Adams School Redevelopment

Addendum No. 3 to Contract Documents

March 30, 2012

Avesta Housing Development Corporation

SHEET C5

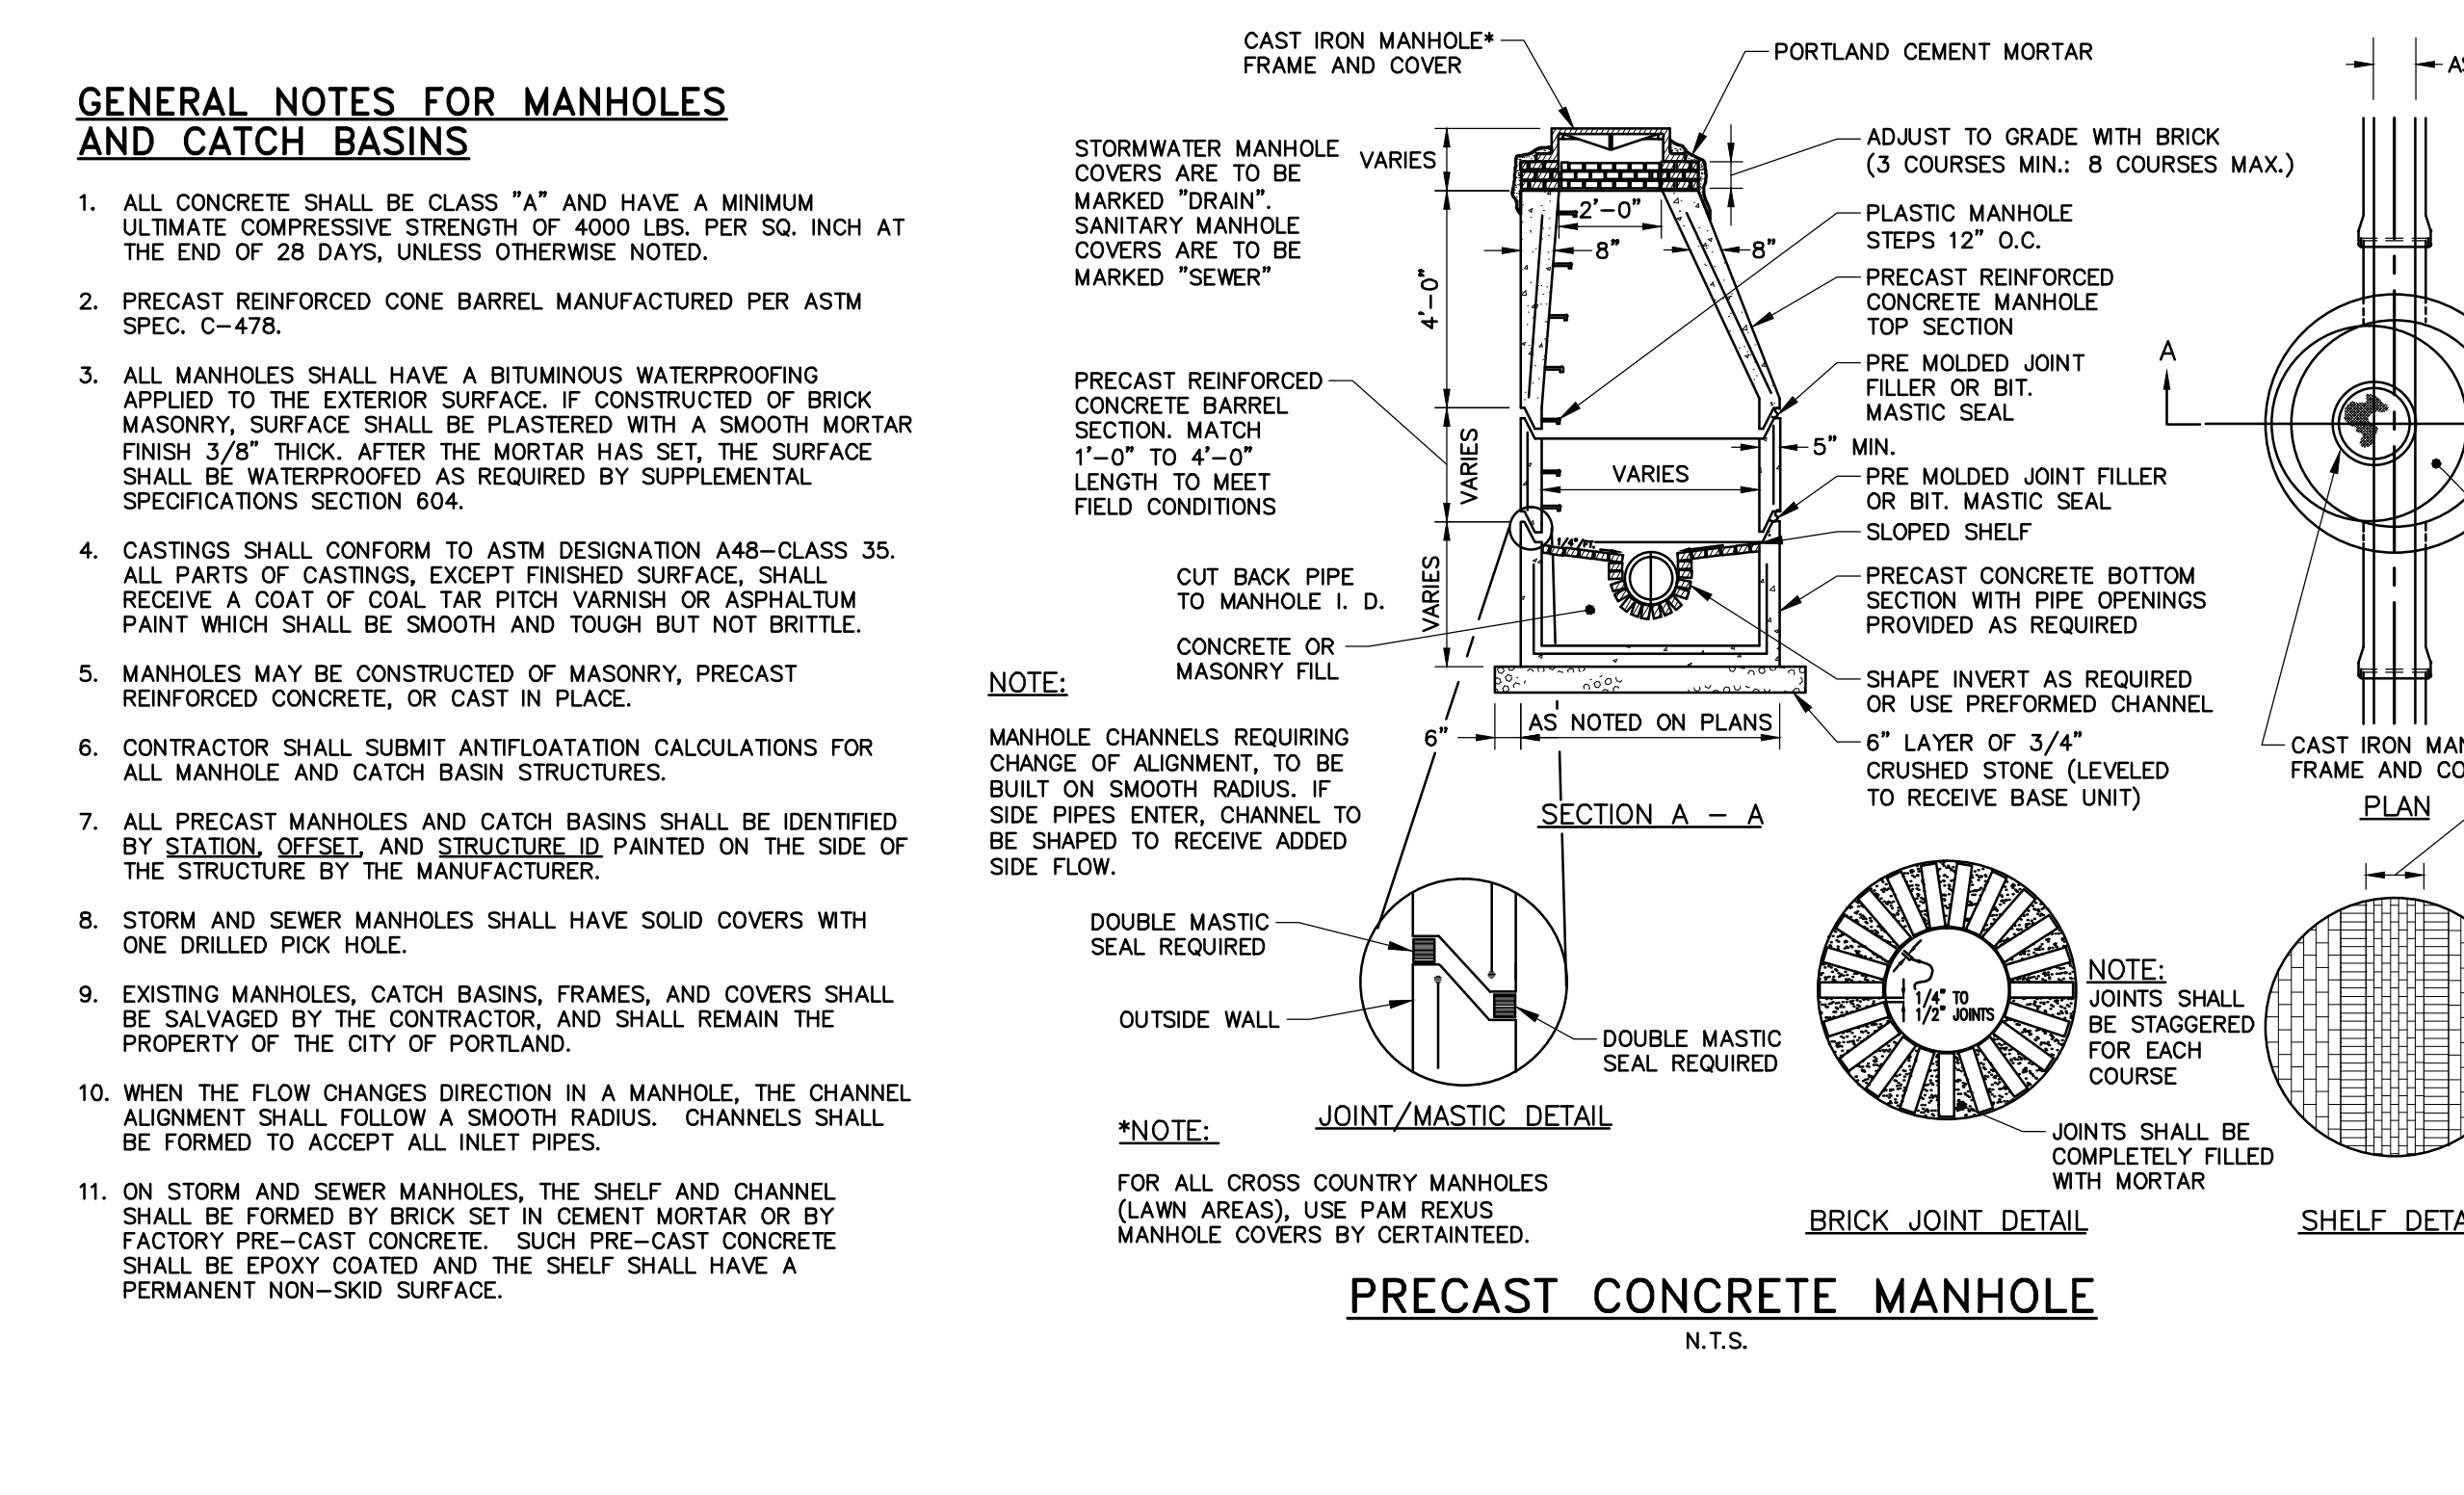
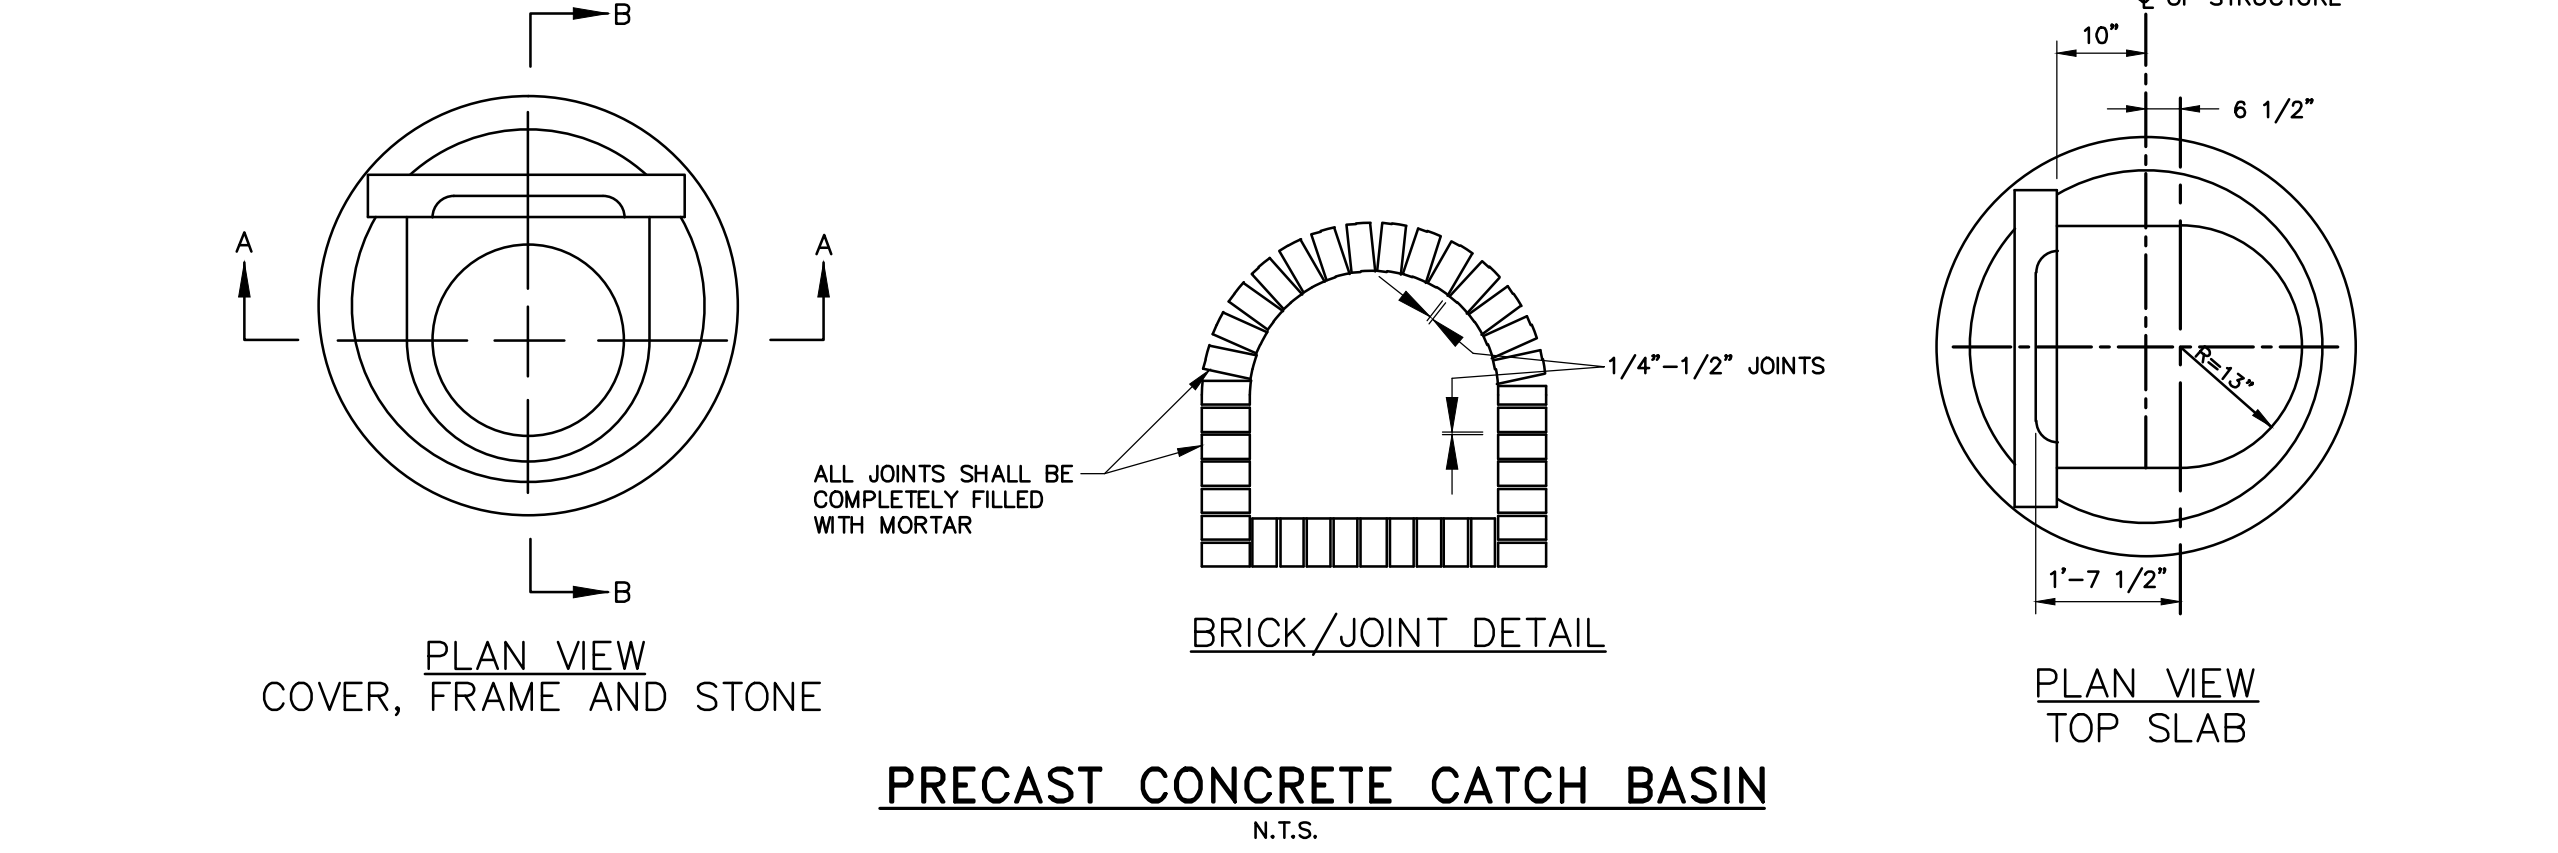
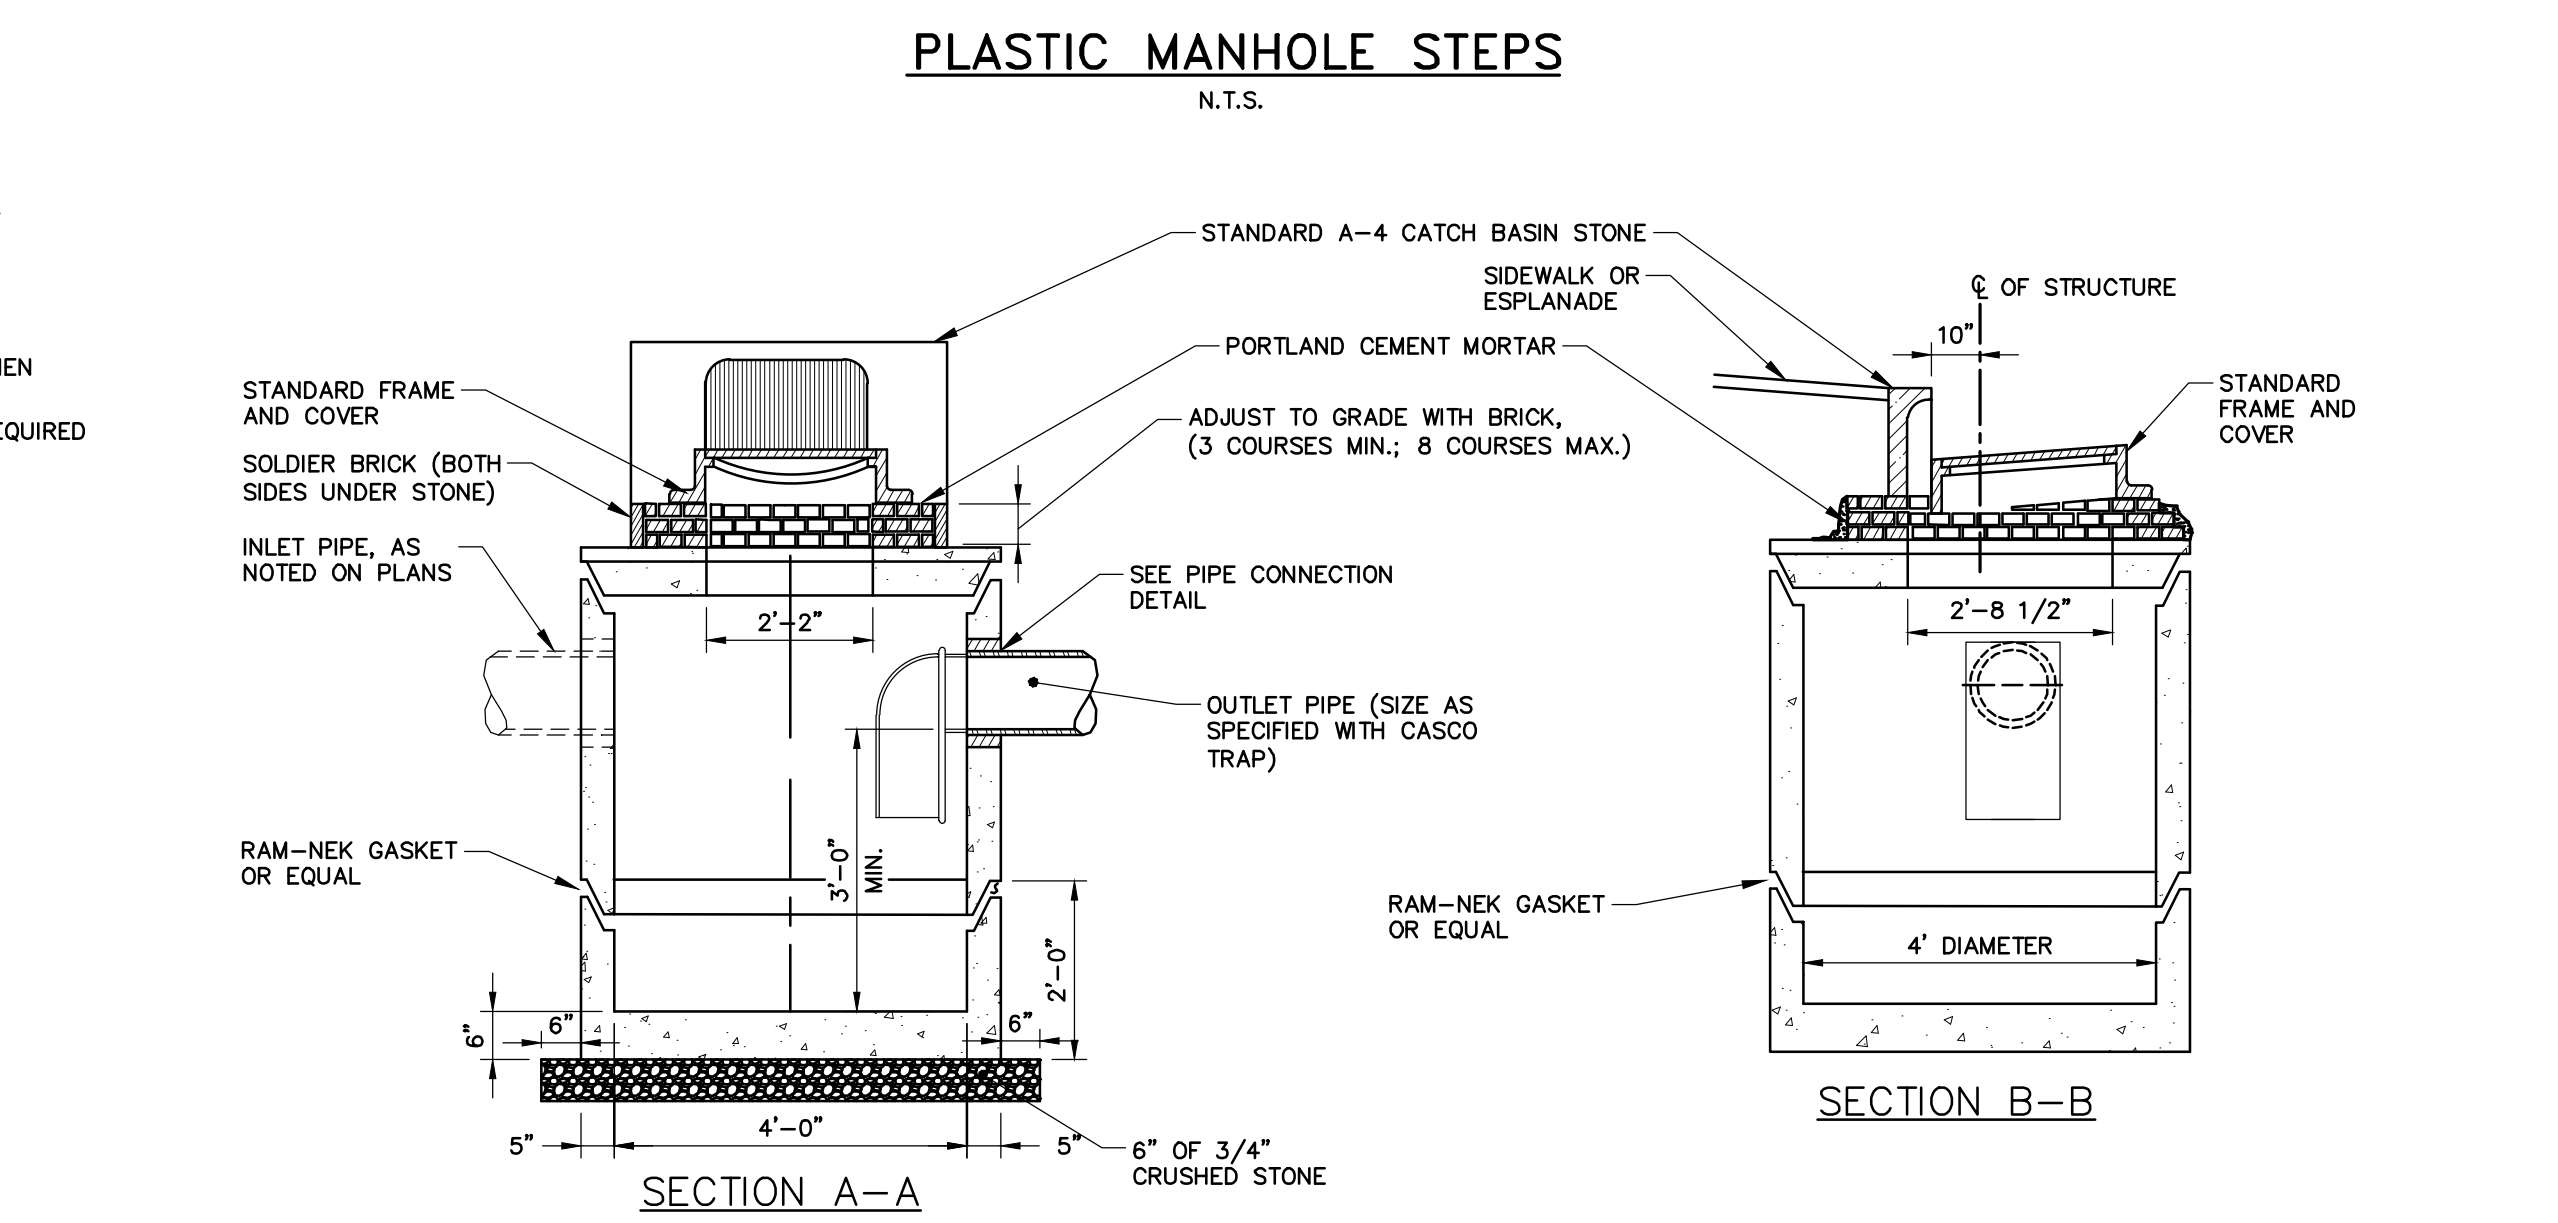
The water services should be constructed as shown. Note that ALL service pipe, on both the main side and building side of each valve will be type K copper tubing. A gate valve with valve box will be required on all service lines, in conformance with the detail provided on Sheet C5, and PWD requirements.

All service pipe will be type K copper tubing. No plastic pipe will be accepted.
